From: Laura Gibbons
Sent: 04 February 2019 13:46
To: Planning.Responses
Cc: Andrew Wood
Subject: RE: Planning Consultation on LU/24/19/DOC

Engineers Comments Regarding Condition 9- surface water drainage

APPLICATION NO: LU/24/19/DOC

Site Address: Former Windroos Nursery Worthing Road Littlehampton BN17 6LY

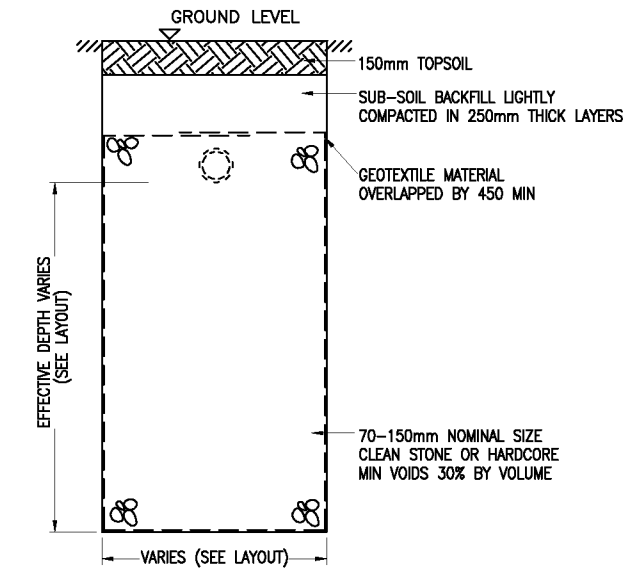
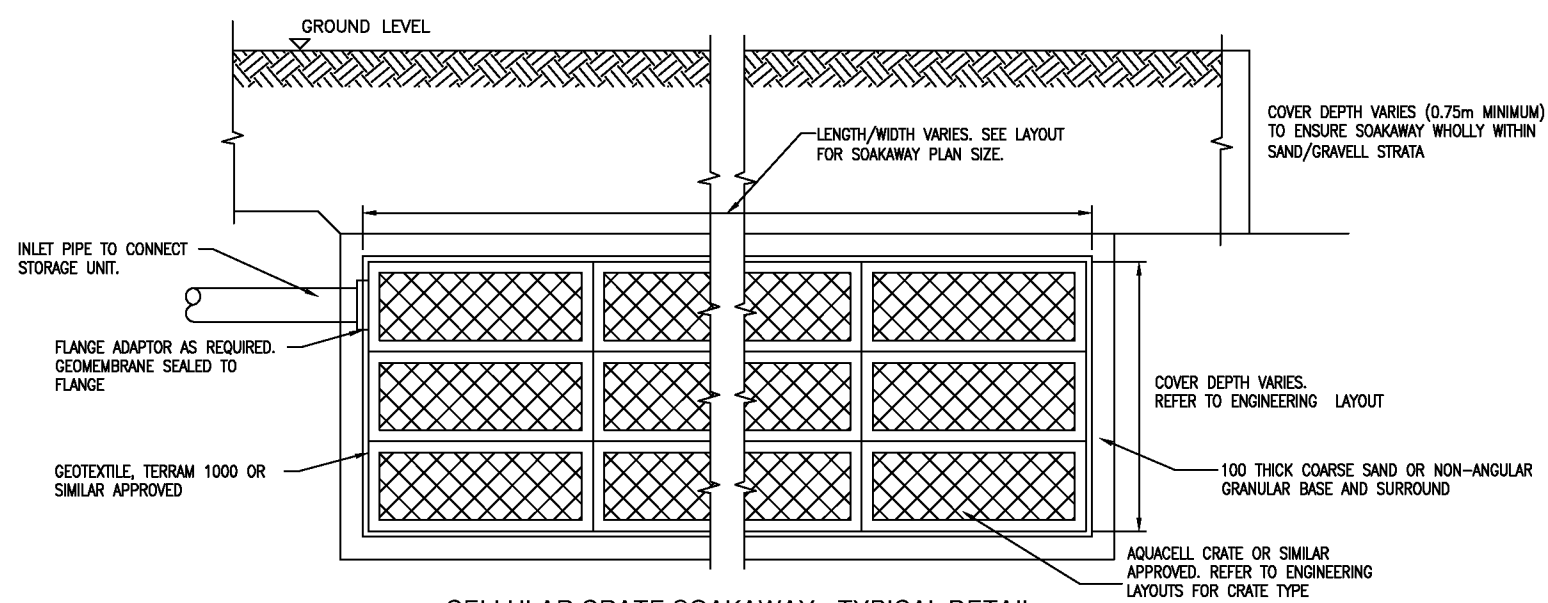
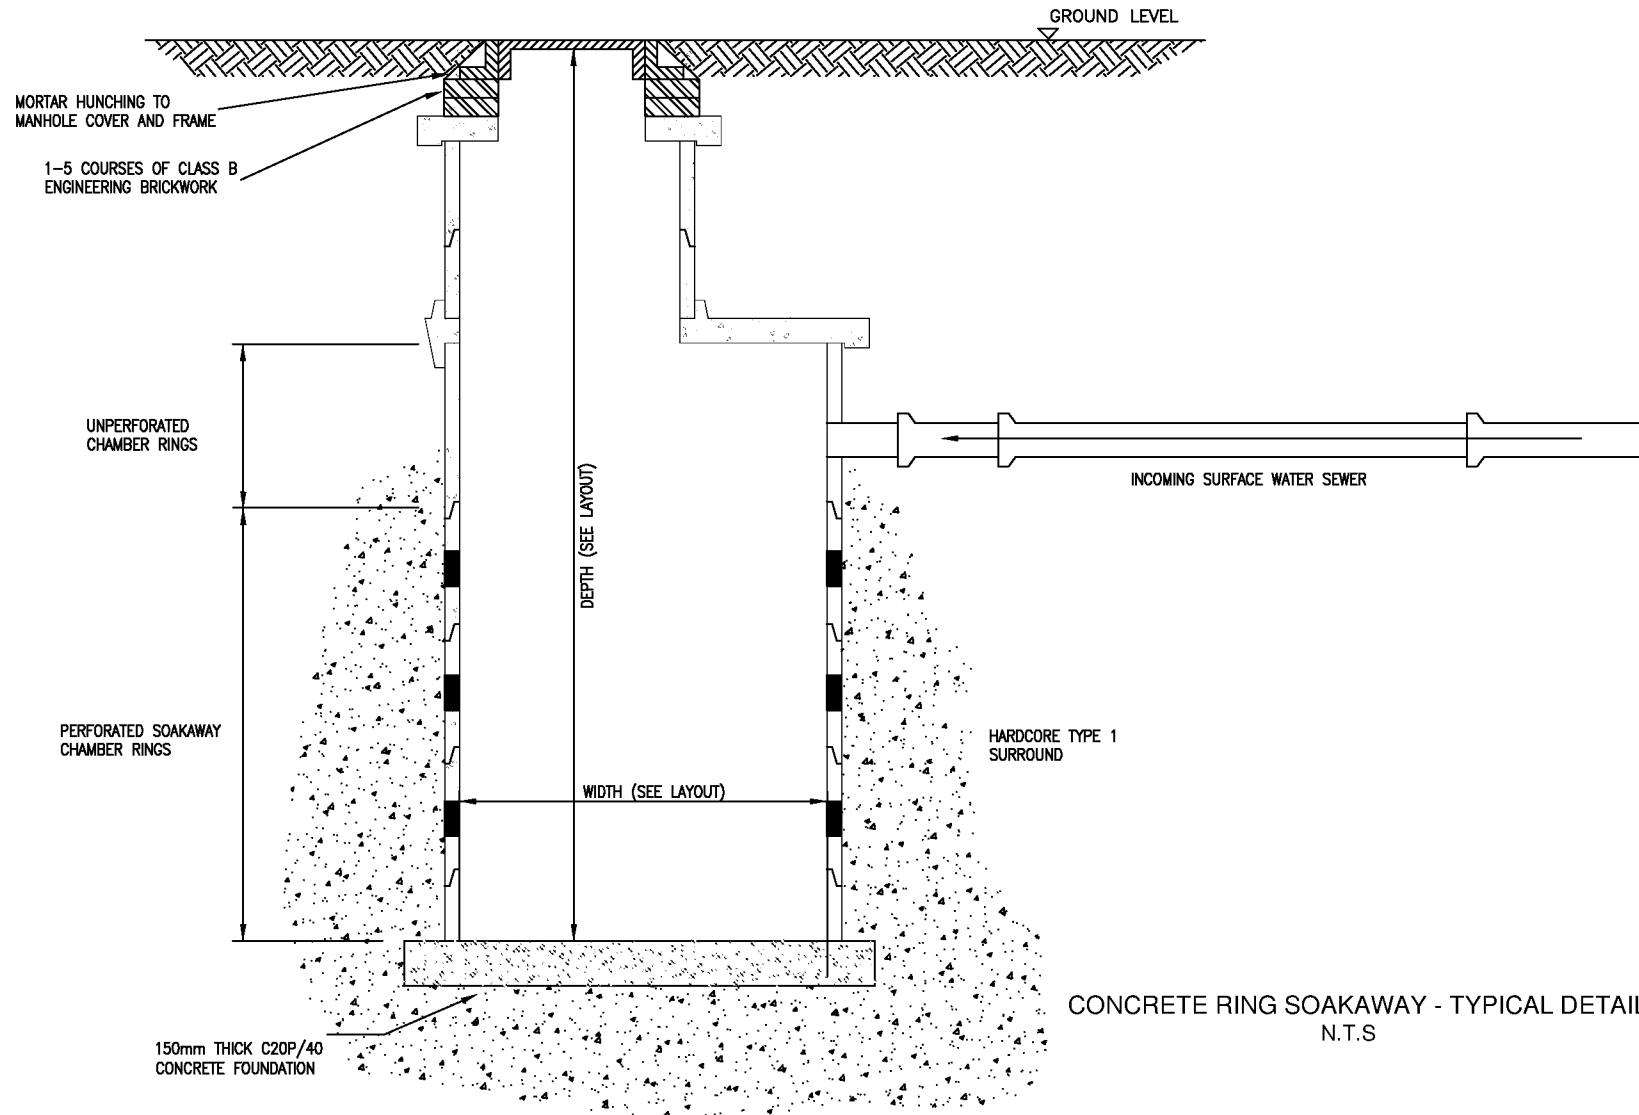
Cellular soakage structures and ring soakaways are proposed, yet calculations have only been supplied for cellular structures.
